Our Ref: PAA/221/16/

Pre-Application Advice

Pre-app advice for extension, dormer, alterations.

No 15 Scott Street Bognor Regis

02 Proposed First Floor Plan

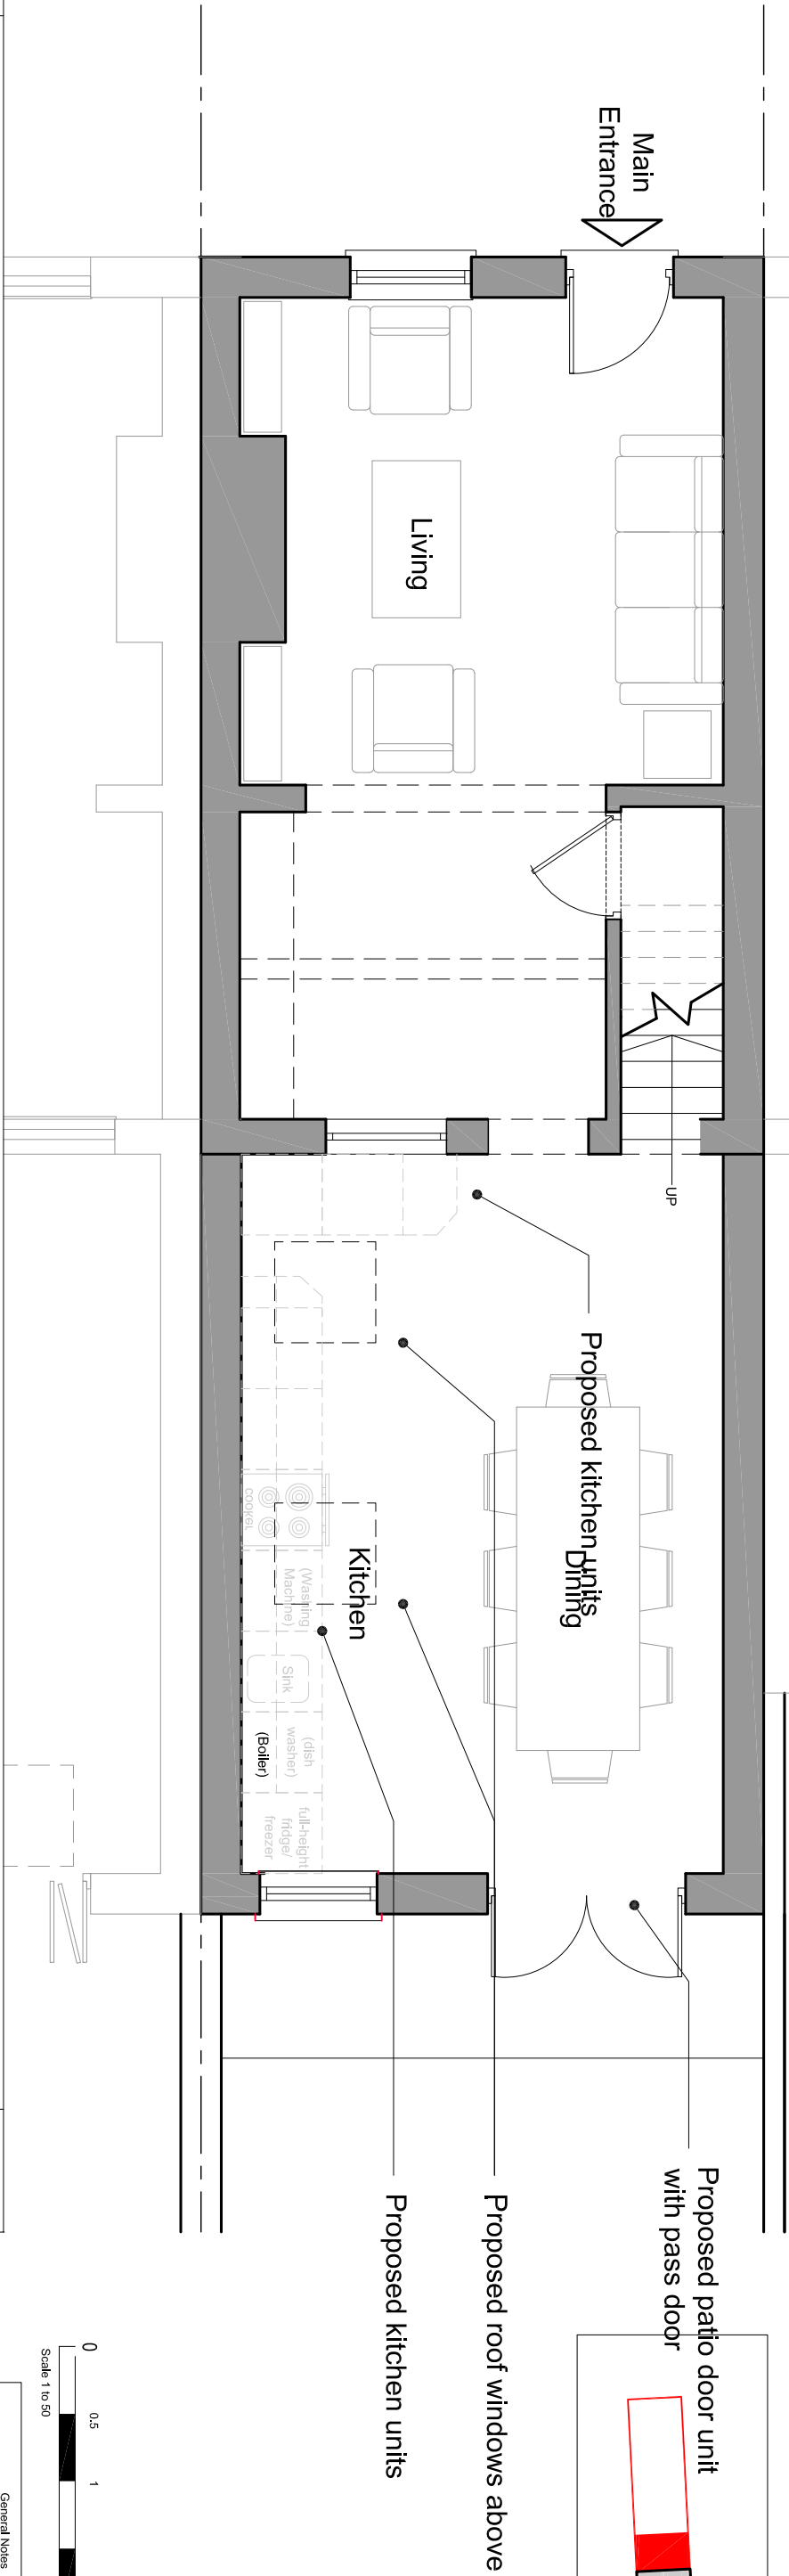
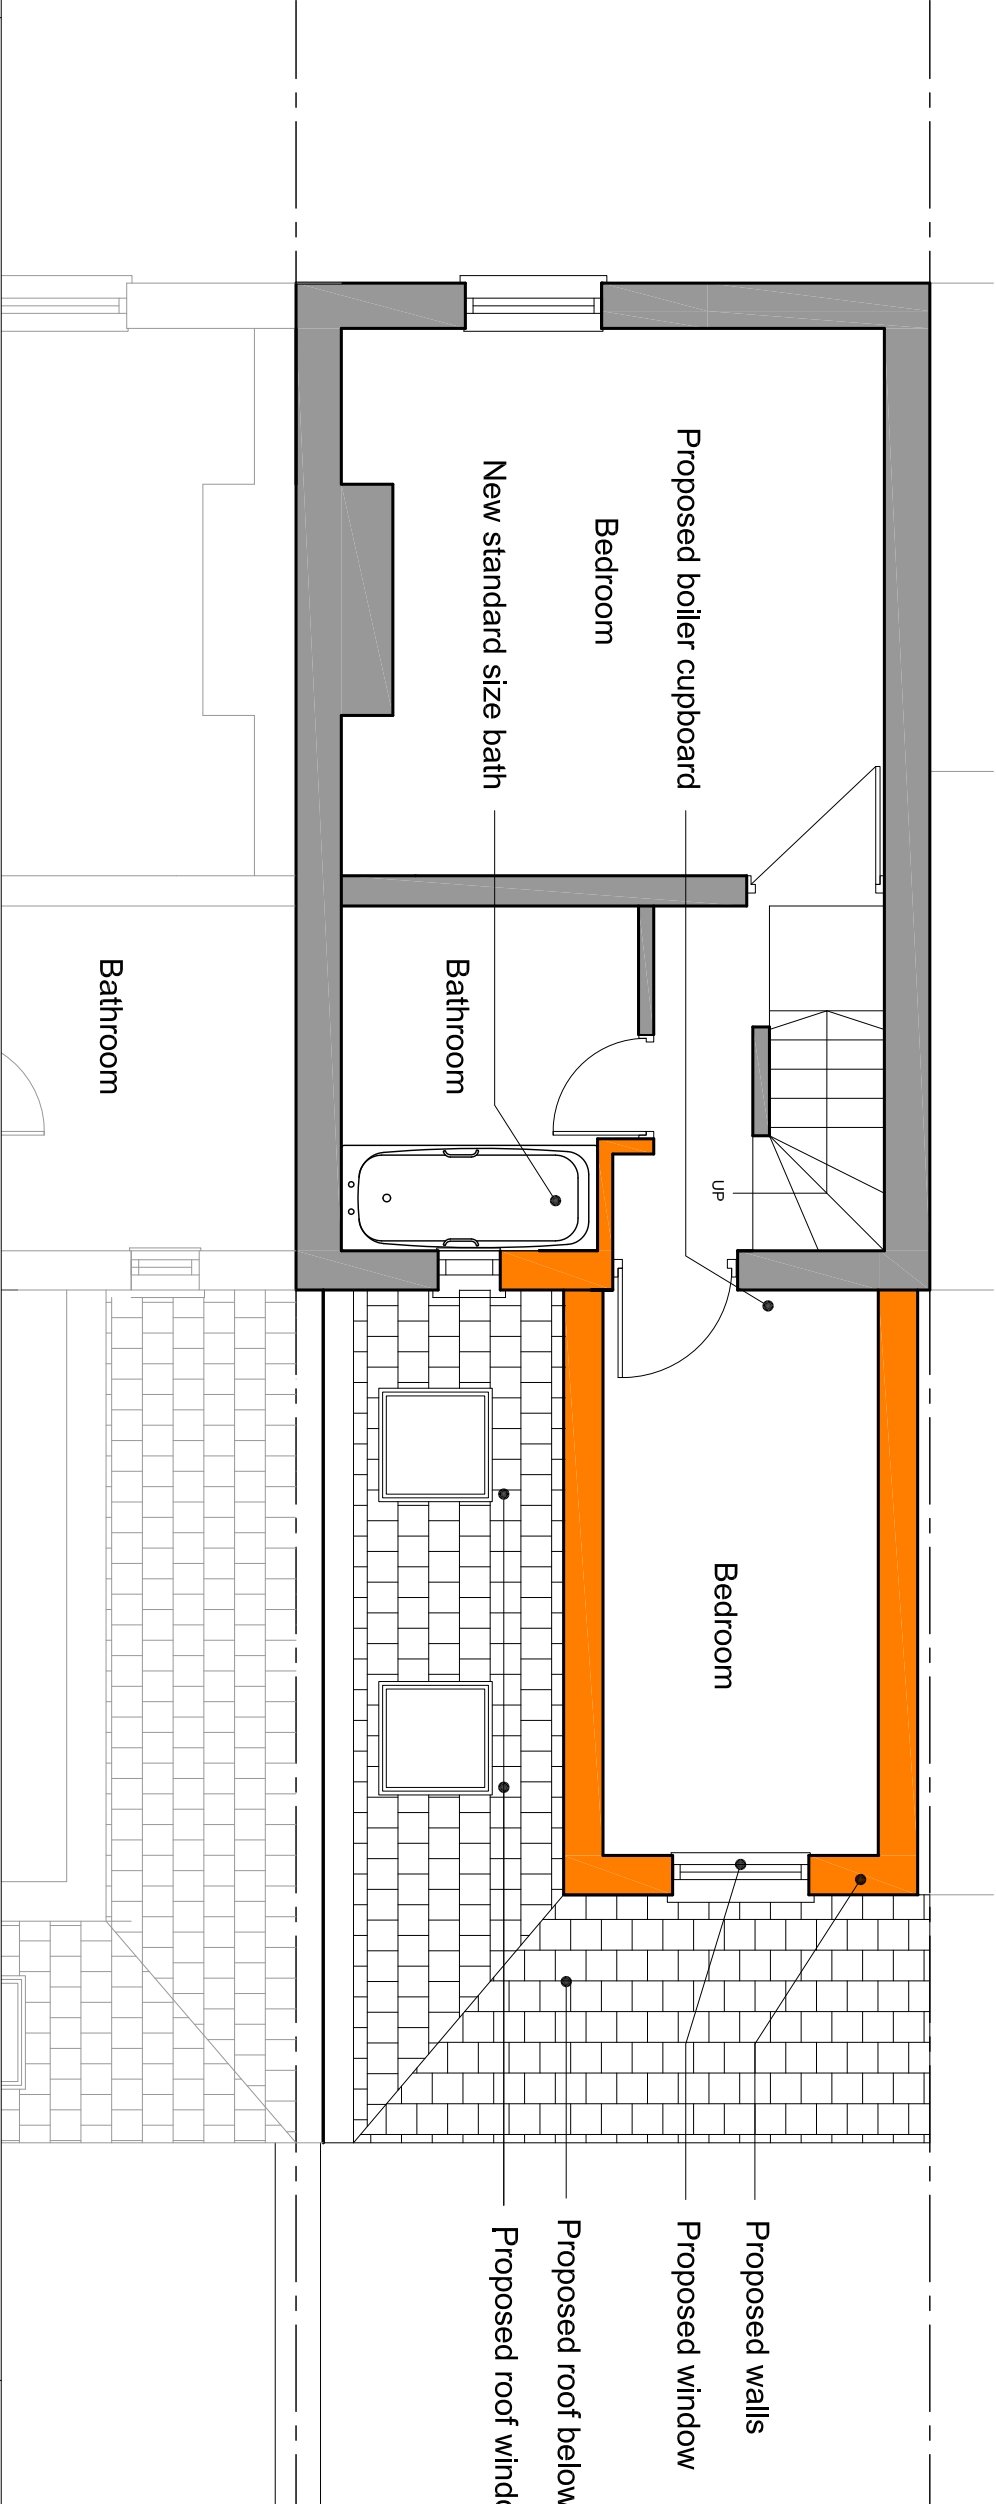
The proposed development is considered to be potentially acceptable in terms of impact on neighbouring residential amenity. The main neighbouring property to be effected would be number 16. This has an existing ground floor rear return. However, a point of contention is that the proposed first floor extension fails the 45 degree test to the middle of the nearest first floor window of number 16. This should be considered prior to an application being made.

Based on the above comments I conclude that were an application for planning permission to be submitted it would be likely to be approved subject to conditions should the 45 degree line issue to number 16's window be addressed. The comments in this letter from the historic buildings officer should also be taken into account and reflected in an application.

01 Proposed Second Floor Plan

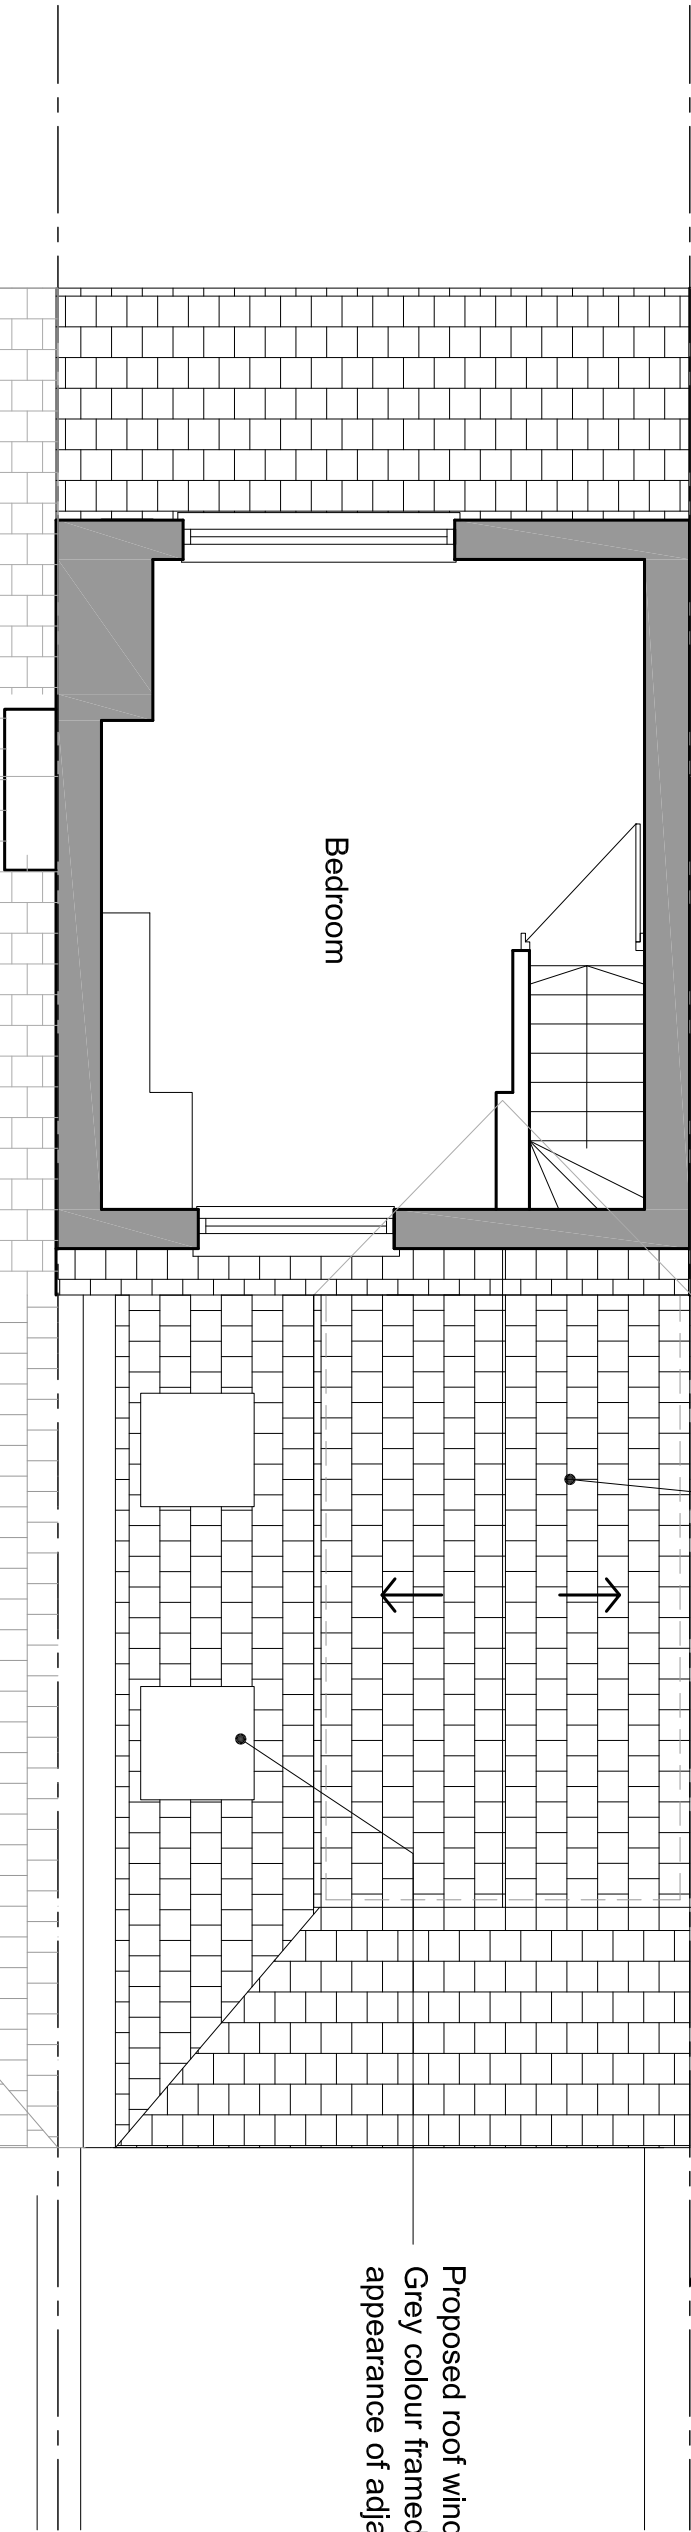
The reduction of the dormer helps to mitigate high level impact and allows the new roof to avoid conflict with it. The roof form is also improved at ground floor level, especially as it now wraps around the two storey element.

01 Proposed South Elevation 1:50

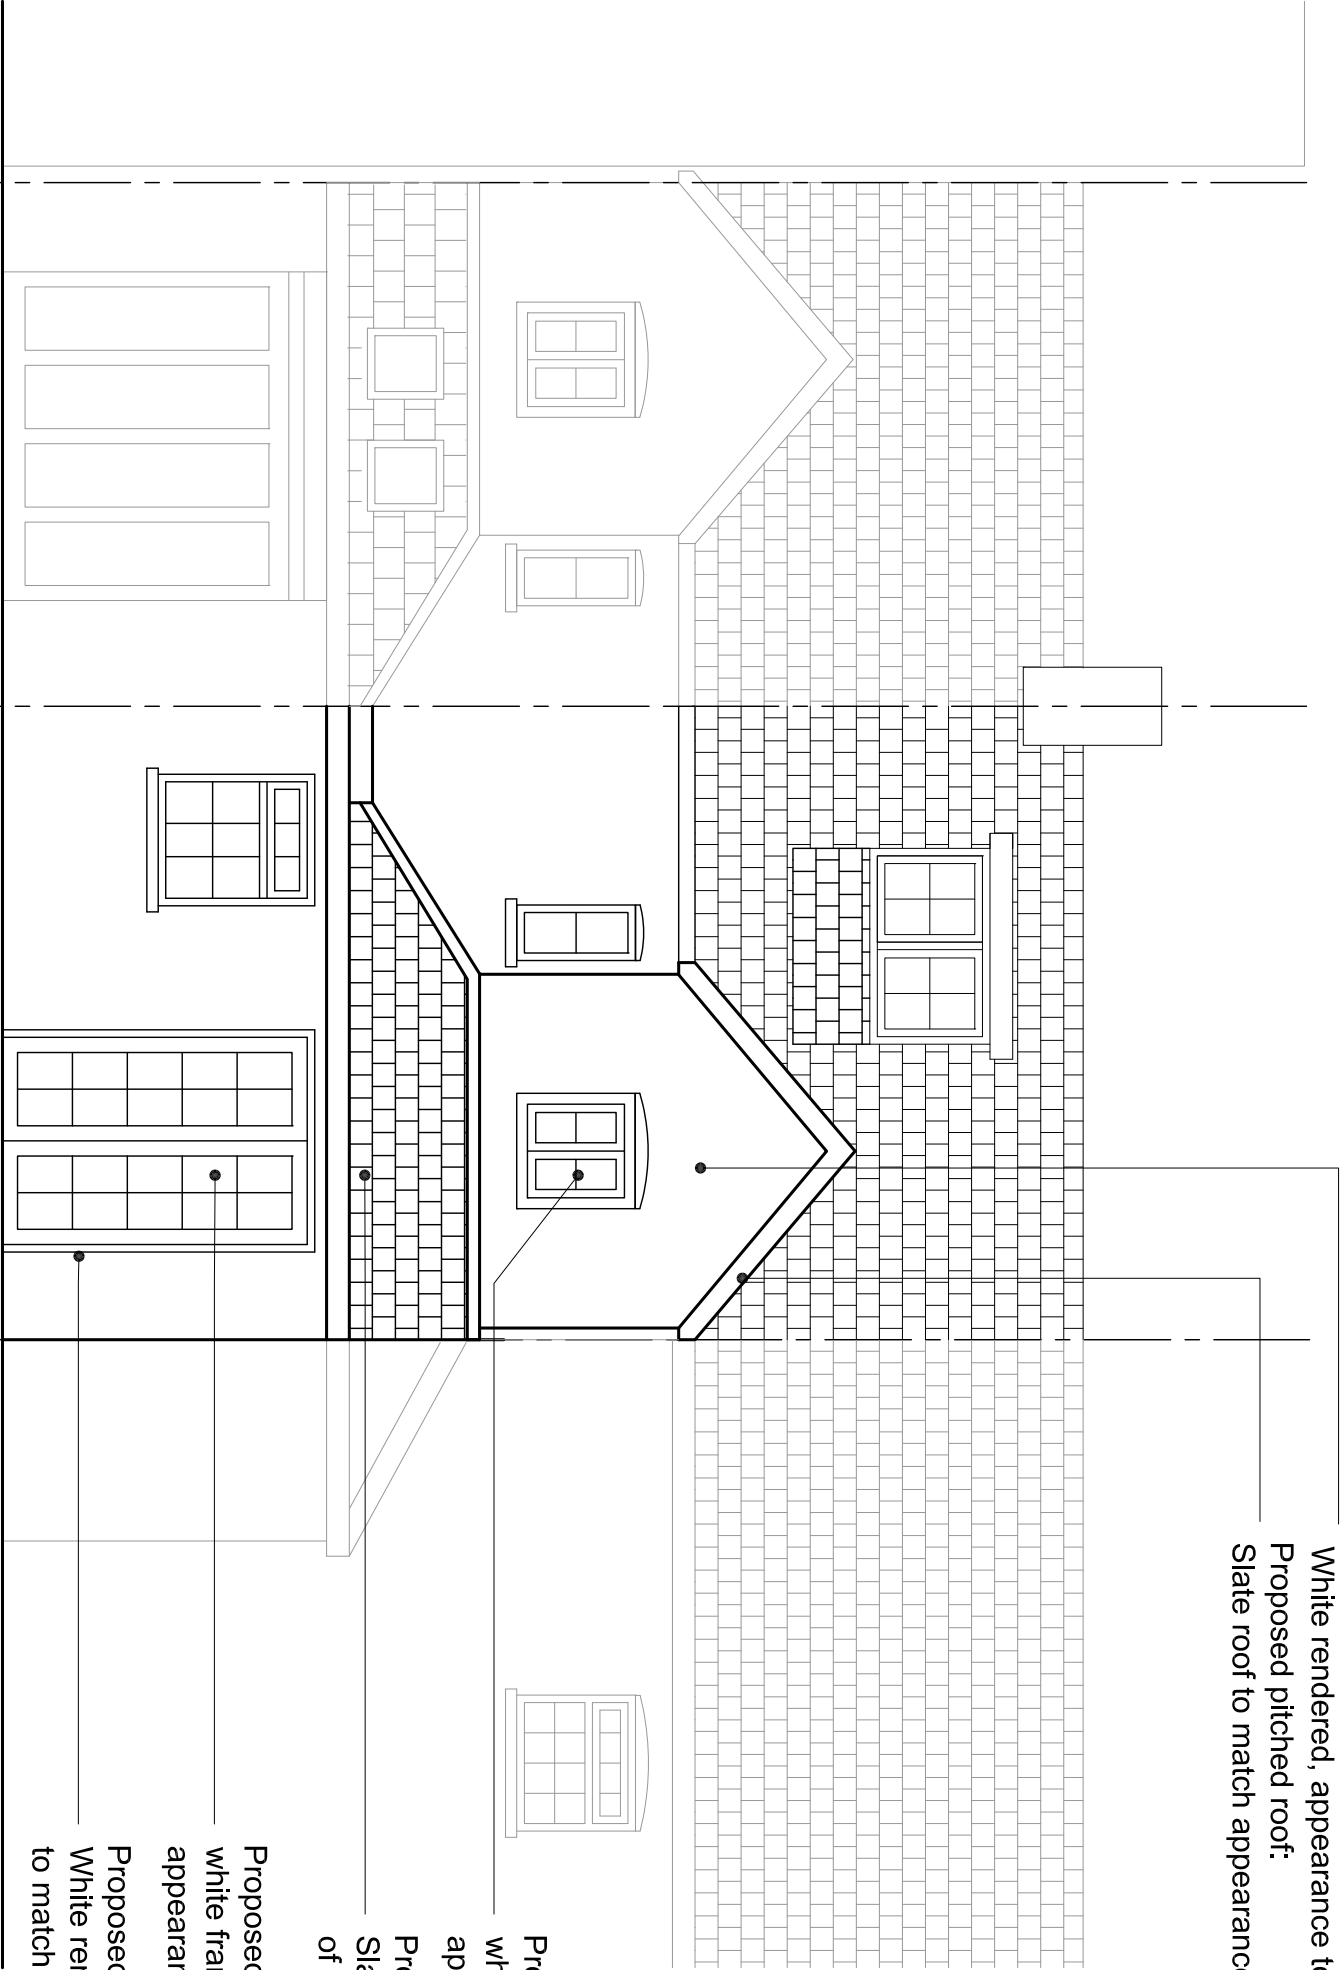
If we were to recommend an enhancement, it would be to amend the ground floor window to a flush casement and to avoid the top-light."
